Appeal Decision

Appeal Ref: APP/R5510/D/20/3263439

55 The Greenway, Ickenham, UB10 8LU

- The appeal is made under section 78 of the Town and Country Planning Act 1990 against a refusal to grant planning permission.
- The appeal is made by Mr Darshan Singh against the decision of the Council of the London Borough of Hillingdon.
- The application Ref 4716/APP/2020/1942, dated 26 June 2020, was refused by notice dated 1 September 2020.
- The development proposed is the extension to existing outbuilding.

PROPOSED SITE PLAN
(SCALE 1:500)

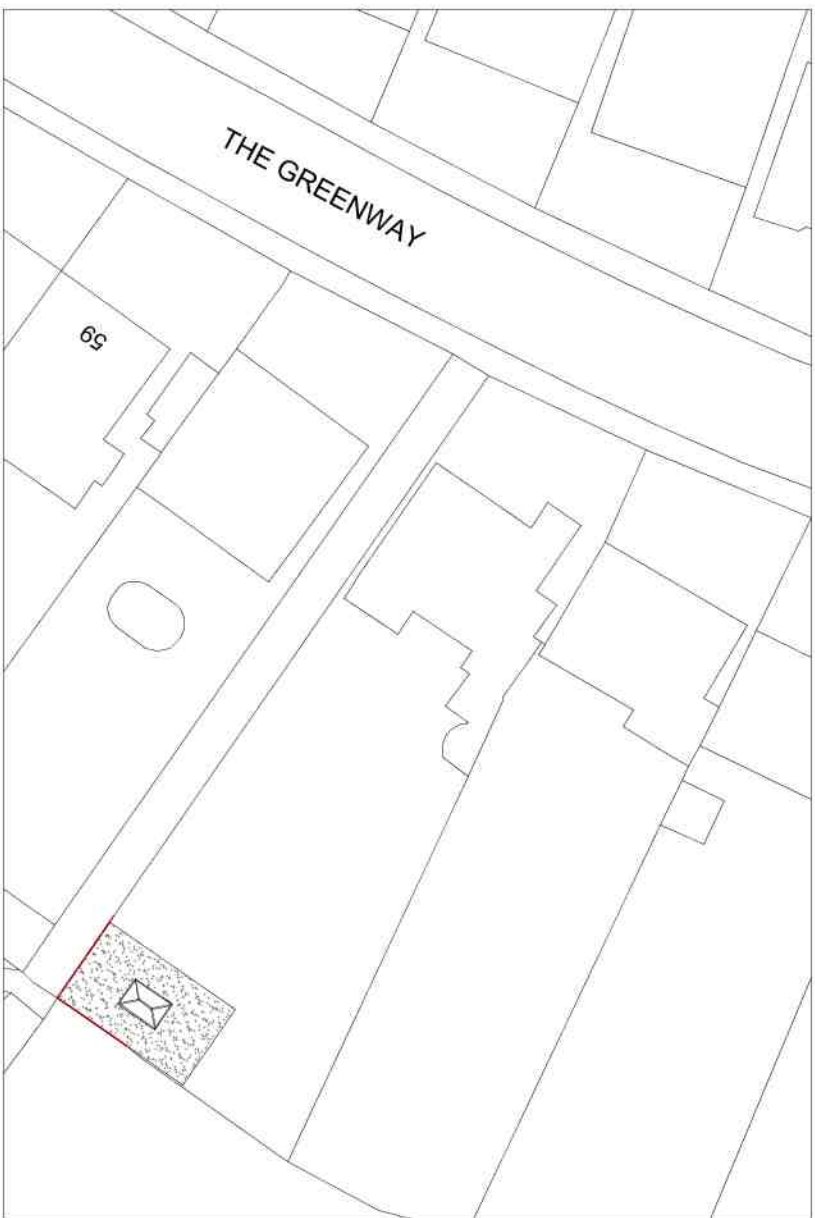
9. Turning to the adjacent oak tree within No. 53's garden, the Tree Preservation Order No.514 map identifies this protected tree as T23, whereas T22 no longer exists. The oak tree is substantial in size and located close to the proposed development. It is an attractive specimen and makes a substantial and positive contribution to the visual amenity of the area (as recognised by its inclusion in the TPO). In the absence of an Arboricultural Impact Assessment (AIA) I cannot attest to what extent the proposed works would affect the roots of the protected tree.

10. Whilst I note there would be a degree of separation between the development and T23, I am not satisfied the principle of the development would necessarily be acceptable. Establishing the extent and form of works which would be deliverable without harming the protected tree goes to the heart of the acceptability of the development. This is a matter which must therefore be resolved prior to the grant of planning permission and not deferred for later consideration by use of a planning condition.

11. I therefore agree with the Council that in the absence of an AIA or other arboricultural assessment, insufficient evidence has been submitted by the appellant with regards to the effect of the proposed development on the adjacent protected tree. In light of the tree's positive visual contribution to the area, its loss would harm the character and appearance of the area.

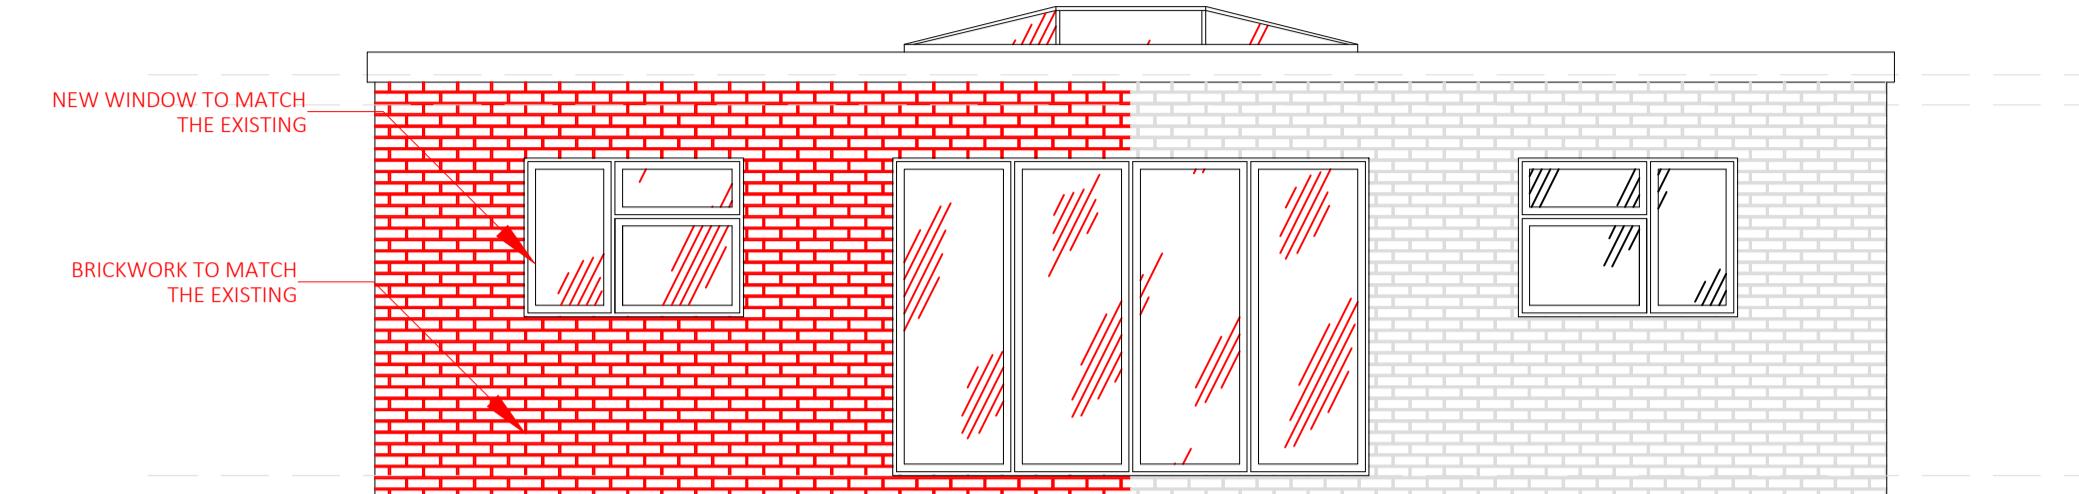
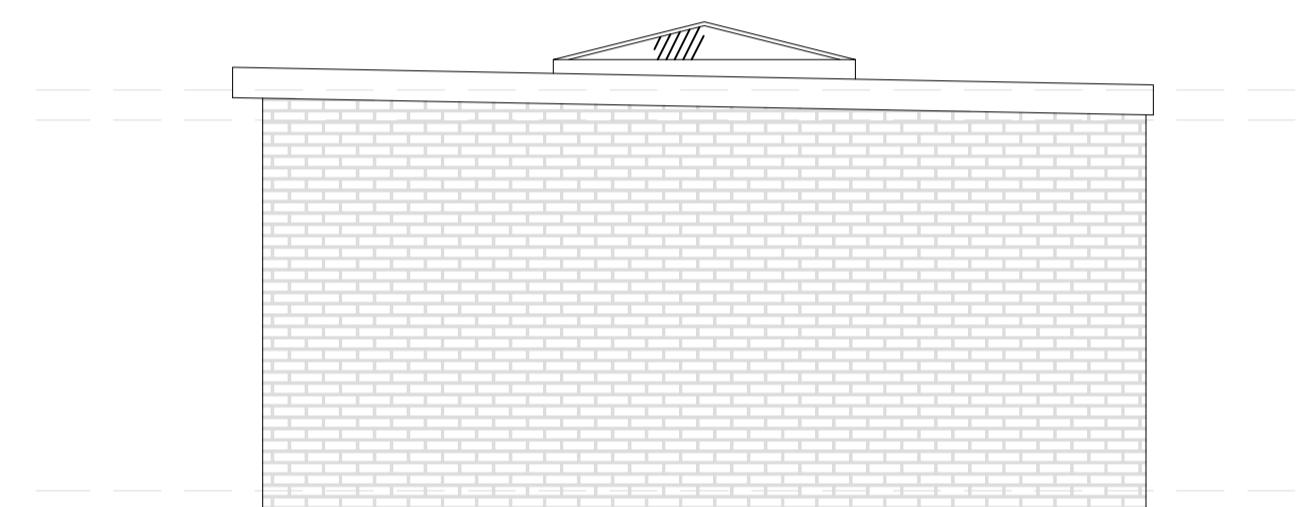
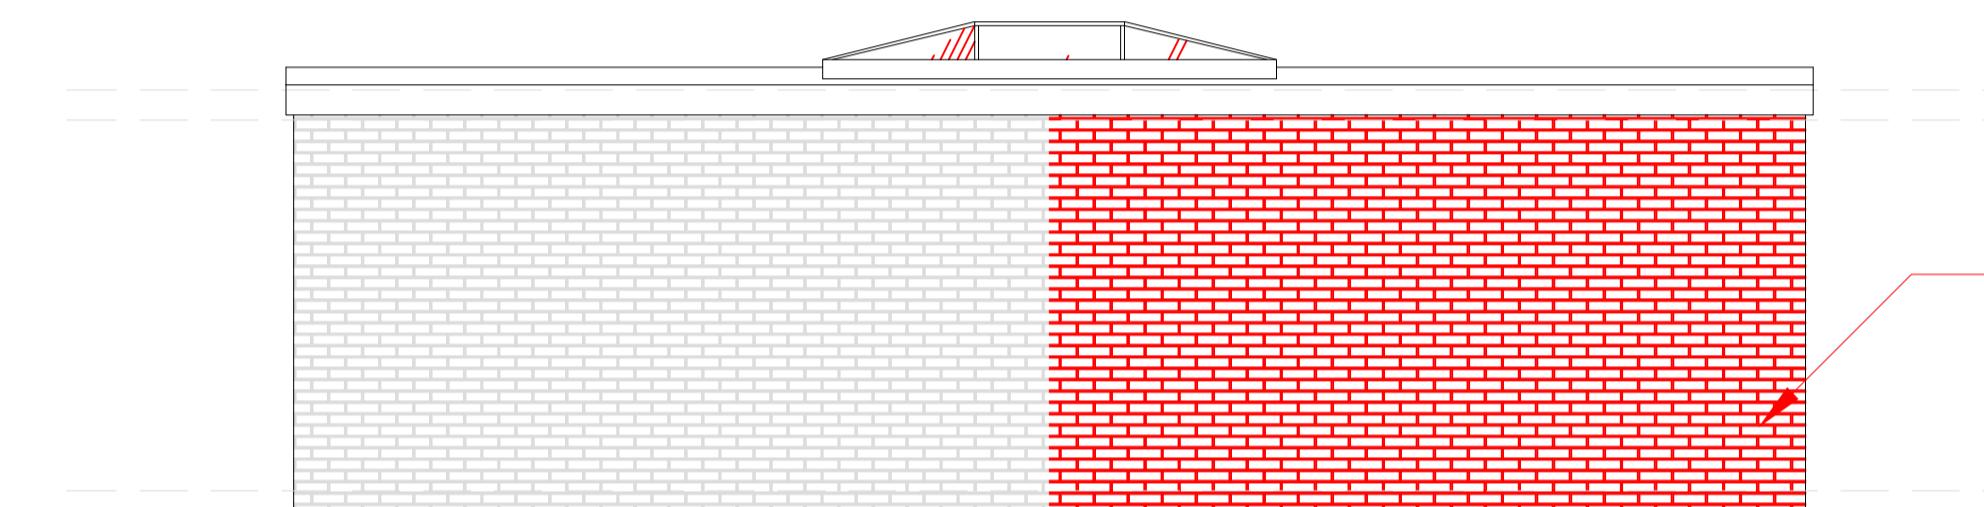
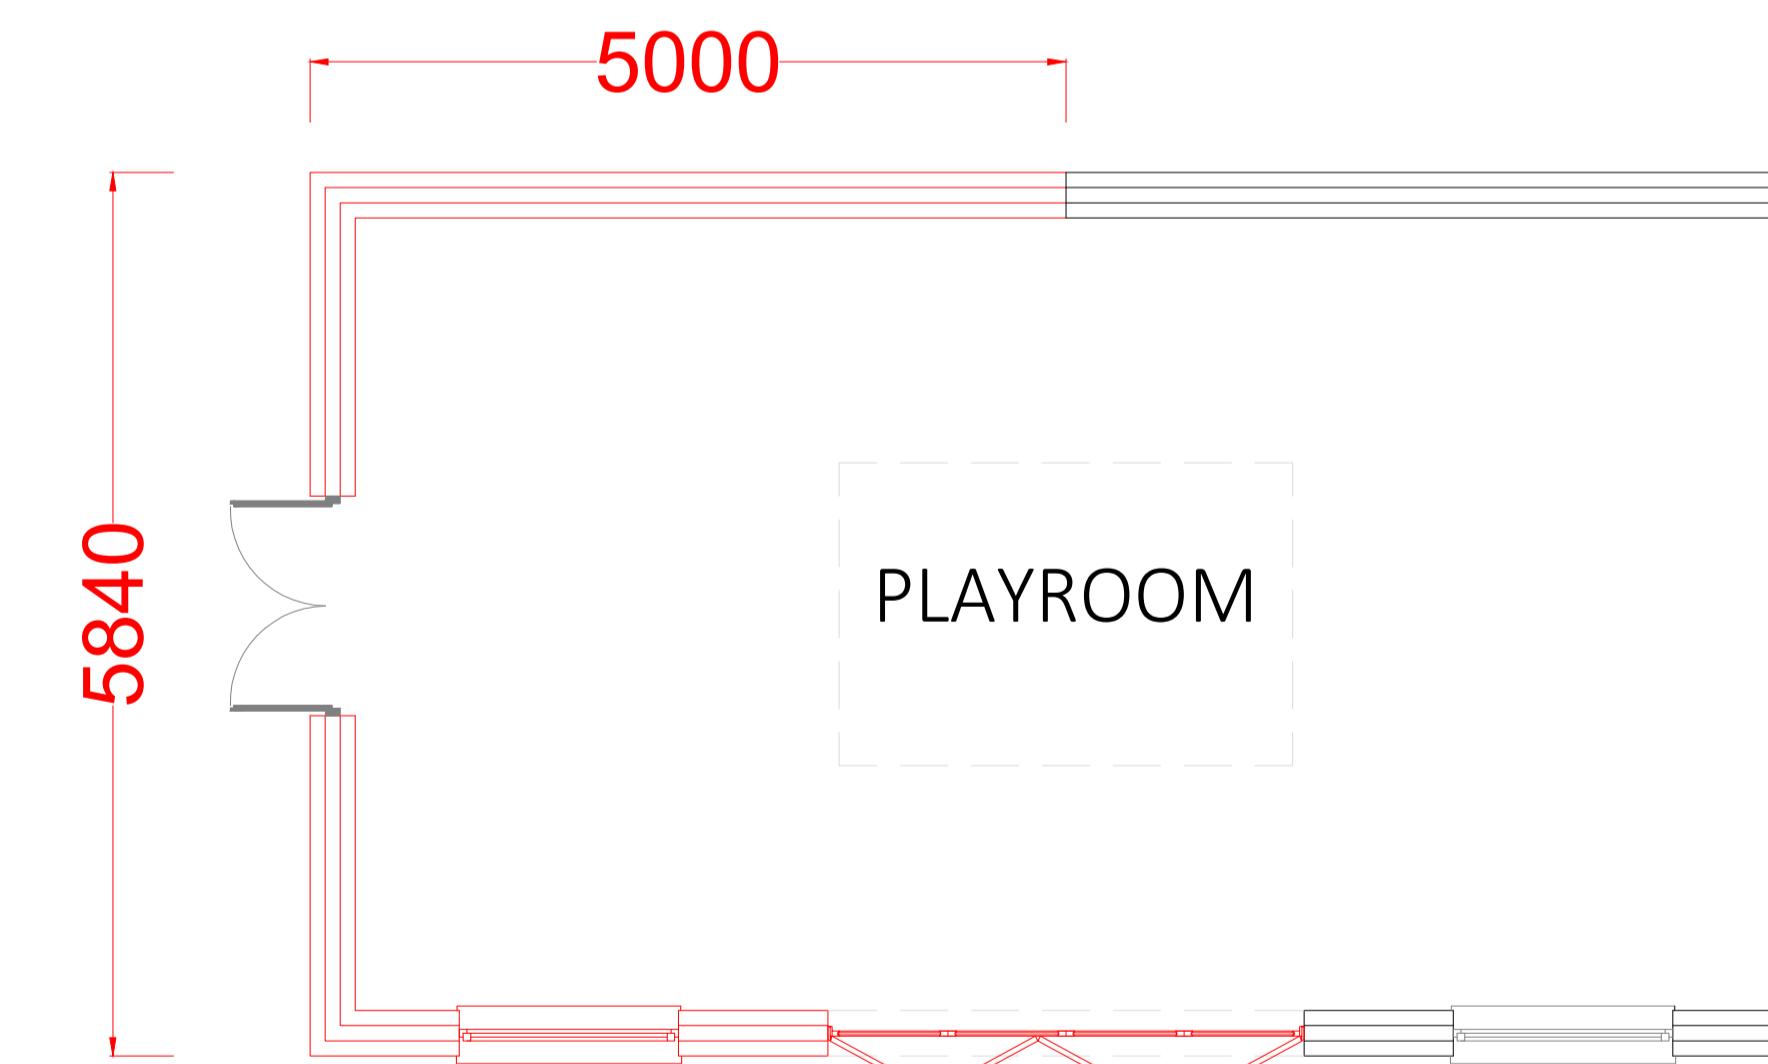
5. Although the resultant outbuilding would exceed 30 sqm, it would not appear excessively large as it would remain subservient in scale to the host dwelling and would be proportionate to the size of the curtilage. I also observed that it would be similar in scale to other large outbuildings associated with neighbouring properties on The Greenway and therefore it would not appear incongruous in this context. The remaining garden area would still be adequately sized and would maintain a degree of spaciousness within the plot.

6. Whilst the enlarged outbuilding would be finished with red brick and would contrast somewhat with the host dwelling that is finished with white render, I do not find it would harm the character of its surroundings, given that many neighbouring properties are built with red brick. It is also not unusual for an outbuilding to be built with different materials to the main house. The overall architectural style would be simple, functional and would thus appear inconspicuous.

7. Furthermore, whilst the development would be visible from the pathway within the parkland to the rear of the site, its relatively modest single-storey height and the thick vegetation directly abutting the boundary would mean it would not appear prominently and would not unacceptably erode the openness and sylvan character of the immediate area.
